Office of
Environment
& Heritage

Your reference: MP 08_0022 Mod 3
Our reference: DOC16/377825
Contact: Peter Ewin
Ph: 6022 0606

RE: Exhibition of Silverton Wind Farm Modification 3 (MP 08_0022 Mod 3)

ATTACHMENT A Detailed comments for Exhibition of Silverton Wind Farm Modification 3

VEGETATION TYPES - NORTH

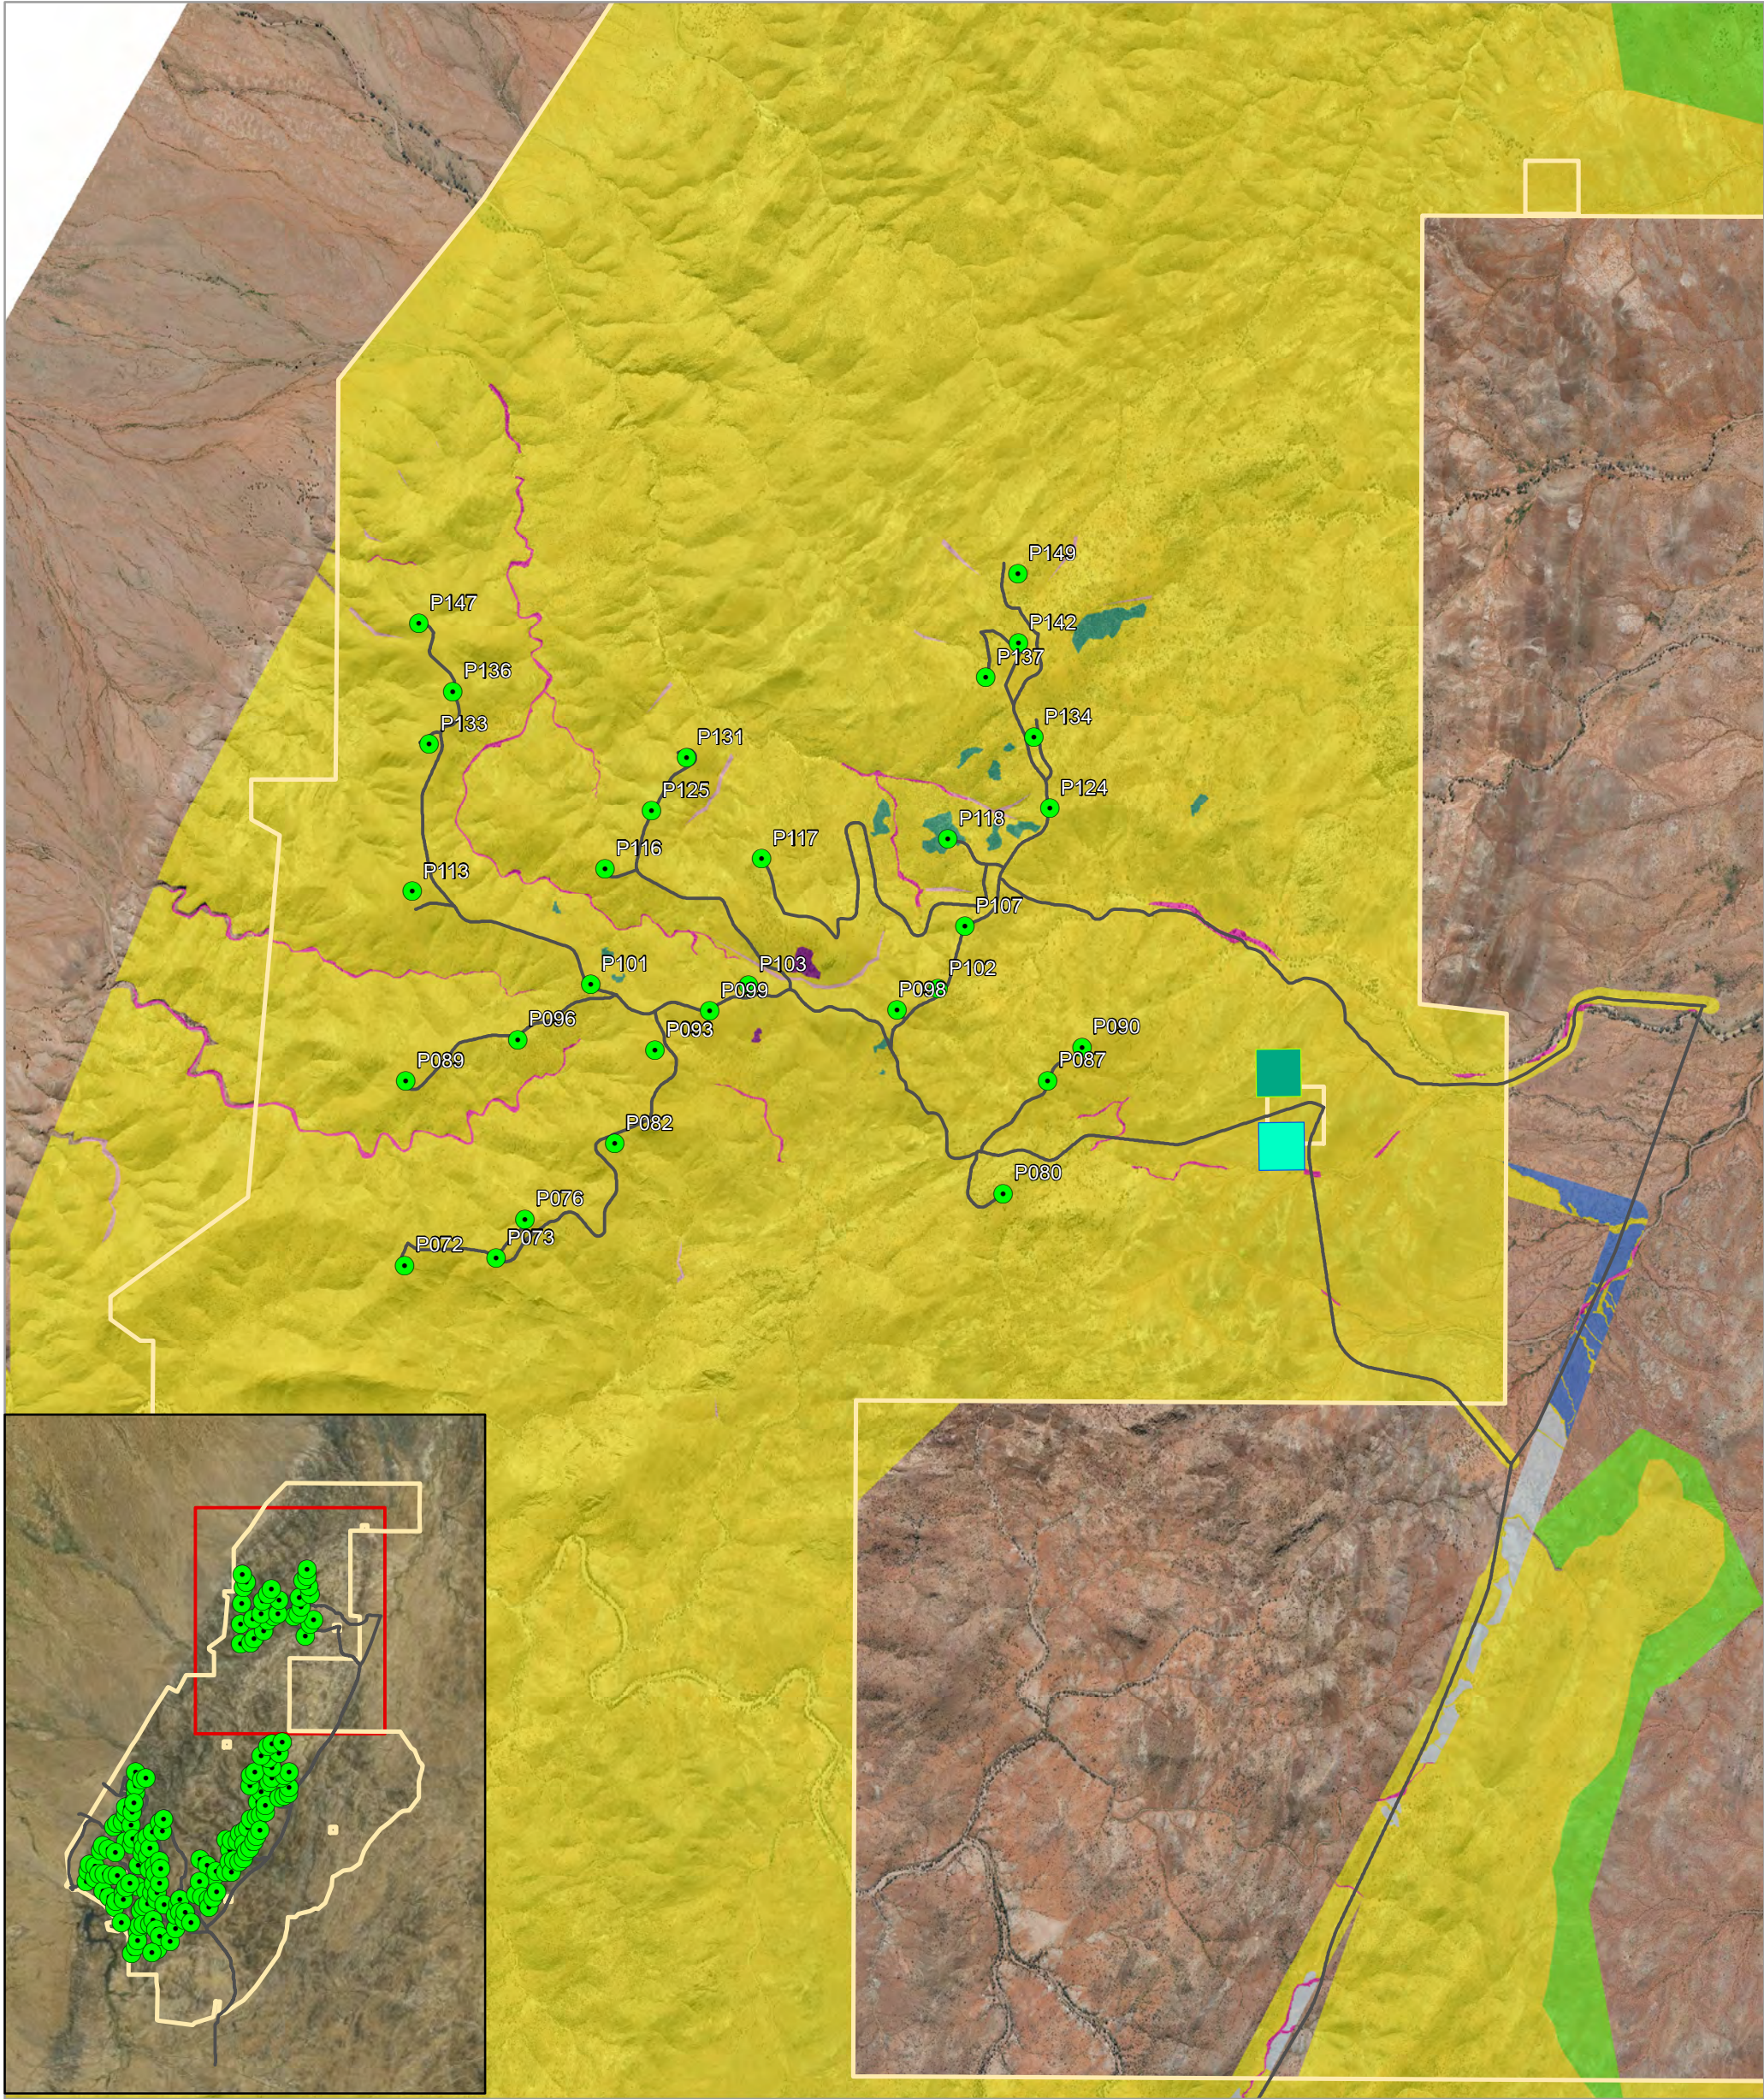
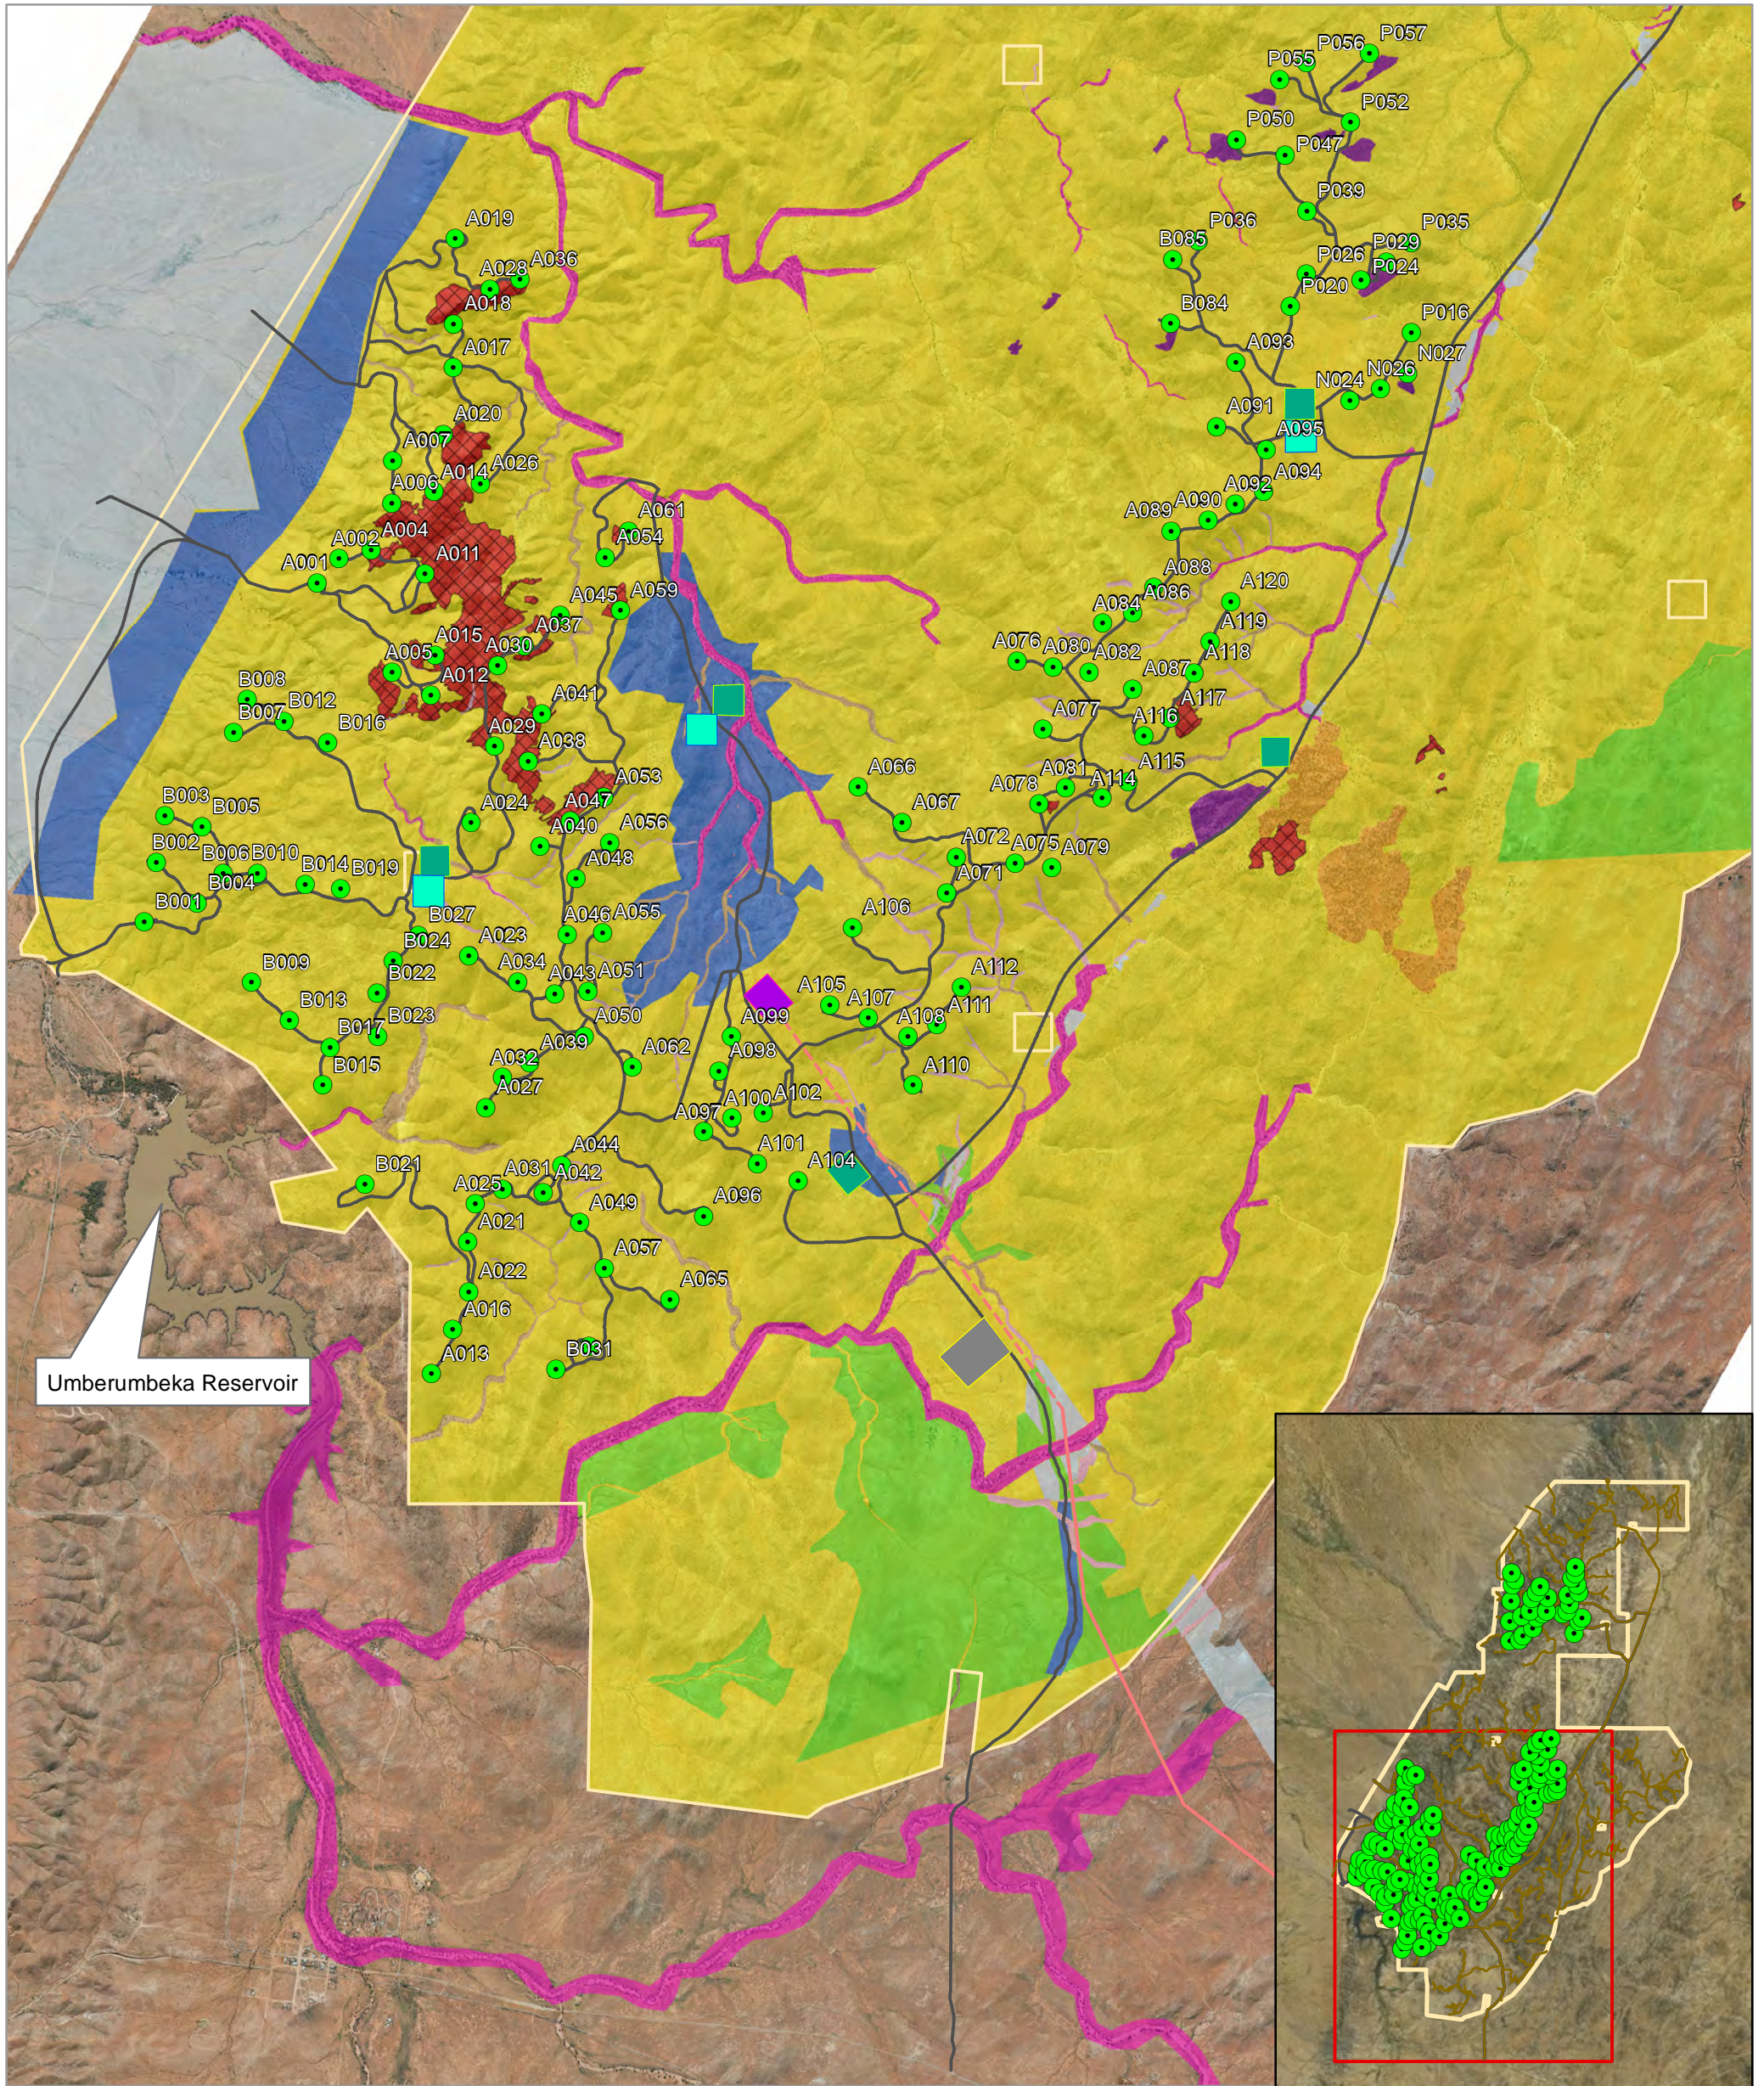
We note that the area of Porcupine Grass – Red Mallee CEEC proposed for clearing is 0.24 ha more than the original development footprint. There is an increased impact now totalling 1.05 ha on this vegetation type, which since the original EA has been listed as critically endangered under the NSW *Threatened Species Conservation Act 1995*.

Table 3.9 notes that some sections of access track occur in areas where vegetation mapping has not been undertaken. It is unclear from the maps where this six hectares occurs. Further discussion of this area is required to address the overall impact of the proposal.
